**Cabramatta Loop Project (SSI-9186)  
Notice of Exhibition**

The relevant documentation within the exhibited Environmental Impact Statement (EIS) has been reviewed and comments with respect to the Technical Report 2 – Noise and Vibration Impact Assessment (TR2) prepared by GHD (Aug 2019) are provided below.

Figure B-1

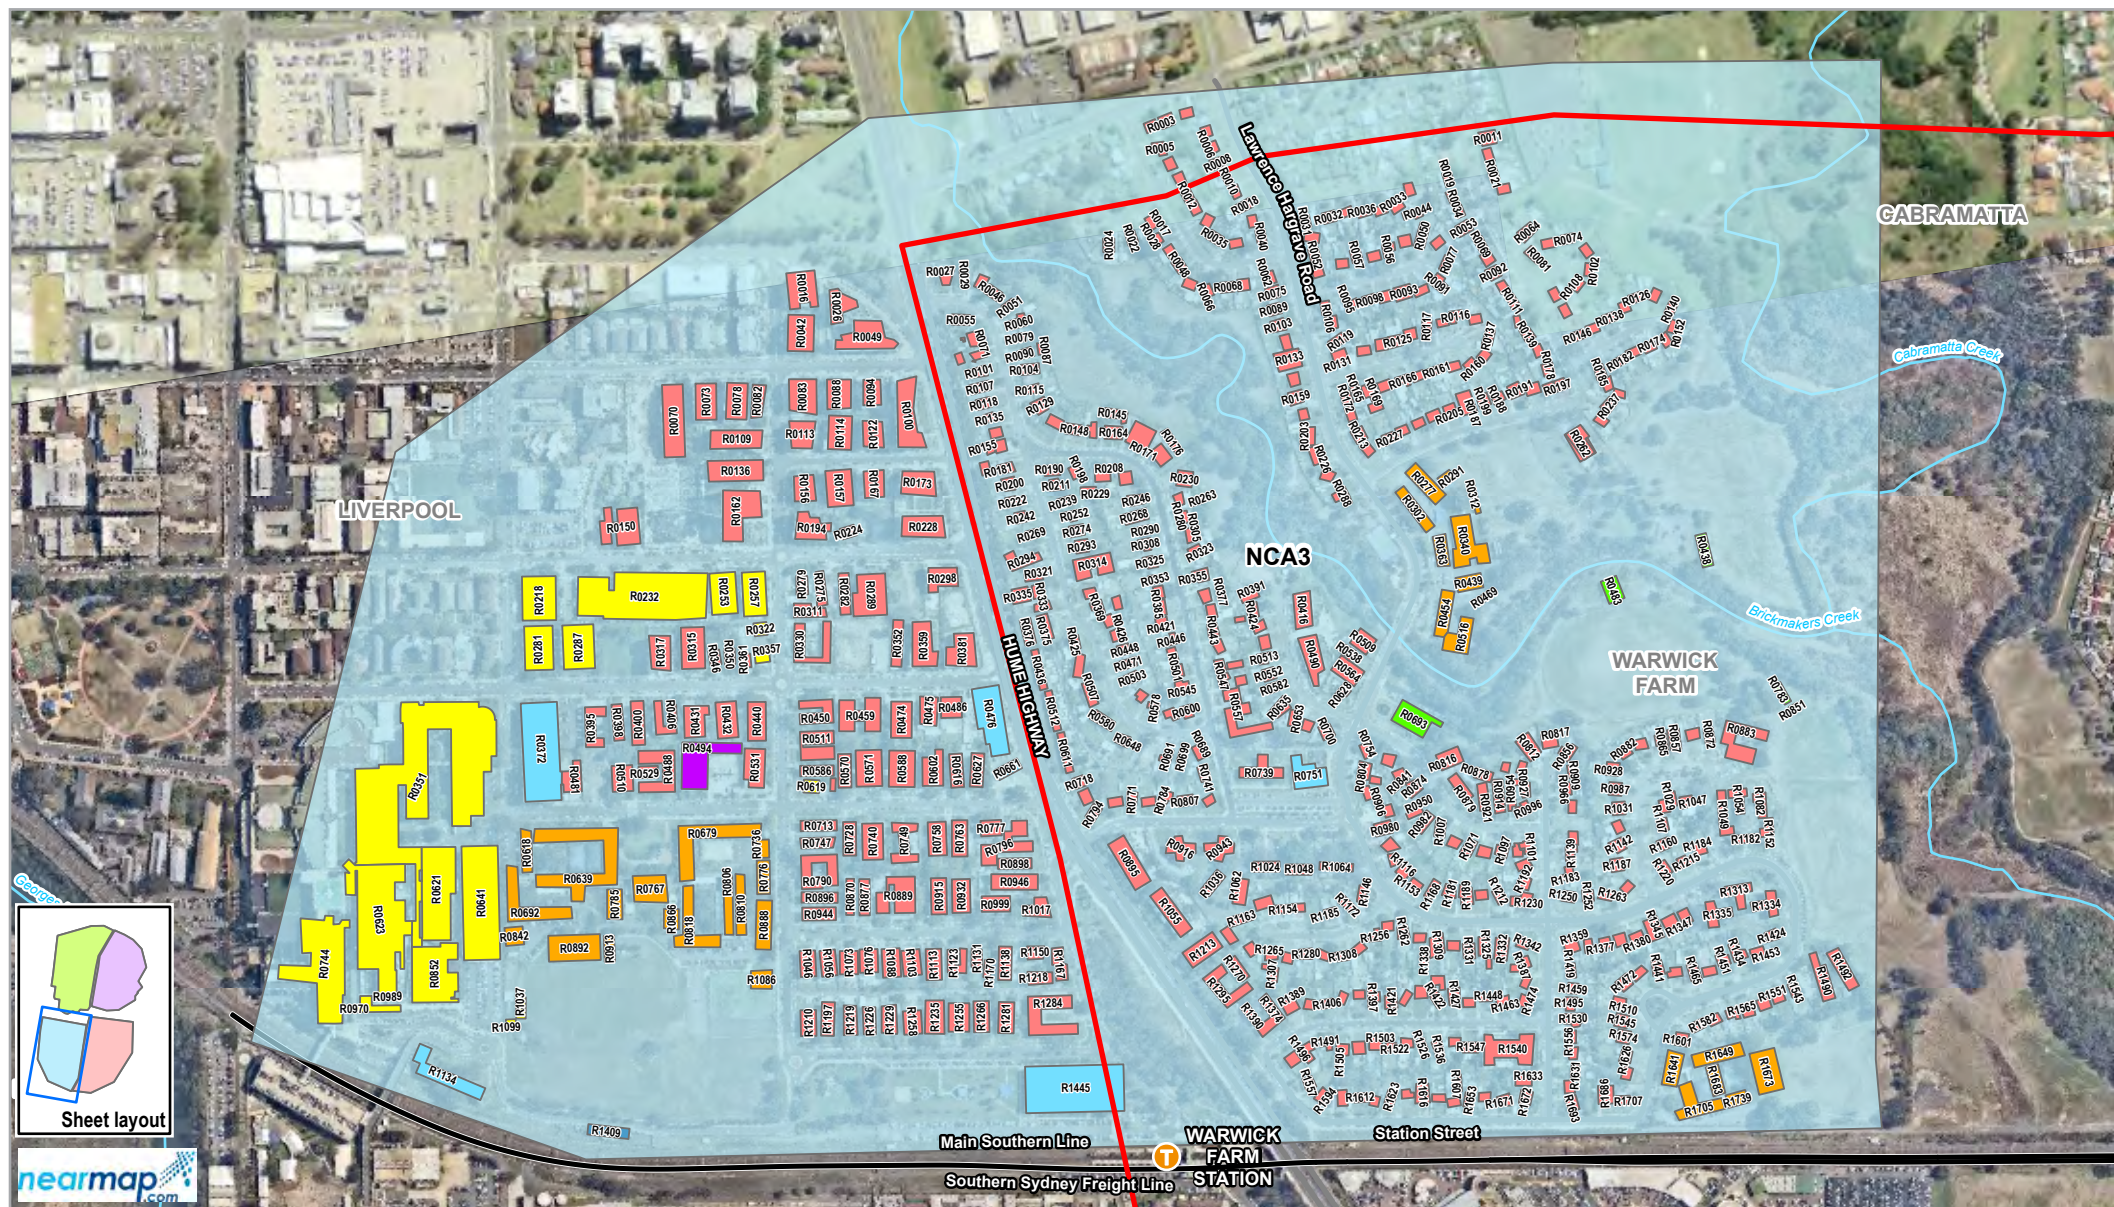
Based on the proposed slew of the ARTC track and new passing loop, the night-time noise levels at 1 Manning Street Warwick Farm (receiver R1773) appear to exceed the noise triggers in the *Rail Infrastructure Noise Guideline* (State of NSW and Environment Protection Authority, 2013). It is noted that there is no existing noise wall adjacent to this property, and no noise wall is proposed as part of the project.

This section states that one property is eligible for noise mitigation, the second floor of 106 Broomfield Street, Cabramatta - Receiver ID R2289. Appendix A of the TR2 however states that Receiver ID R2289 is 108 Broomfield Street Cabramatta.

It is recommended that ARTC confirms which properties qualify for noise mitigation.

It is recommended the noise report is updated to clarify which properties require noise mitigation, noting there are two units on the 2<sup>nd</sup> floor of 108 Broomfield Street Cabramatta. The report should also justify why other floors in that building are not treated given technical note 6 of EPA's *Rail Infrastructure Noise Guideline*.
